**Subject:** FW: Planning Consultation on: P/70/19/RES

Engineers Comments Regarding Surface Water Drainage

**APPLICATION NO: P/70/19/RES**

**Site Address:** Land North of Summer Lane Pagham PO21 4NG

DRAWING TITLE
Proposed Site Plan
90 Unit Scheme

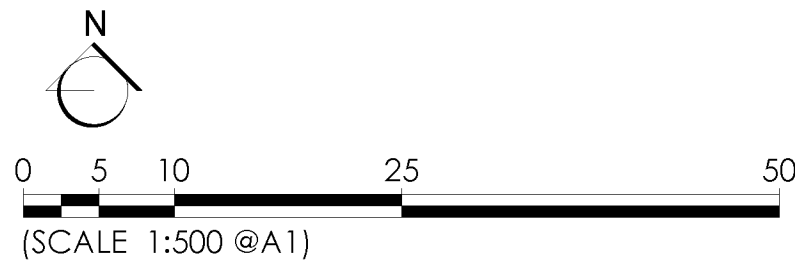
The proposed layout includes proposals for numerous accessways over the watercourse immediately to the north of Summer Lane. We have significant concerns regarding these proposals due to the risk of blockage, loss of habitat, loss of capacity and increased difficulties with maintenance. ADC has a no culverting policy.

It is unclear what the proposals are for the culverted watercourse to the north west of the site. Please can this be clarified. Further survey should be completed to determine if there are any further connections into the watercourse.

The proposals are to take water from the adjacent development through the on site SuDS, using weirs as overflows to allow for this flow. It is unclear how it will be ensured that the development does not increase flows to the watercourse. Proposing a weir for the discharge from the adjacent site is an oversimplification of the situation. In reality there will be a base flow through the watercourse from the adjacent site, surface water from the site will then also discharge into the SuDS. Water from the two sources will both be within the SuDS and therefore water from the site itself will also utilise the weirs in significant rainfall events and therefore not be controlled up to and including the 1 in 100 year plus climate change event as required and stated. I will provide a further review of calculations once this significant issues has been resolved.
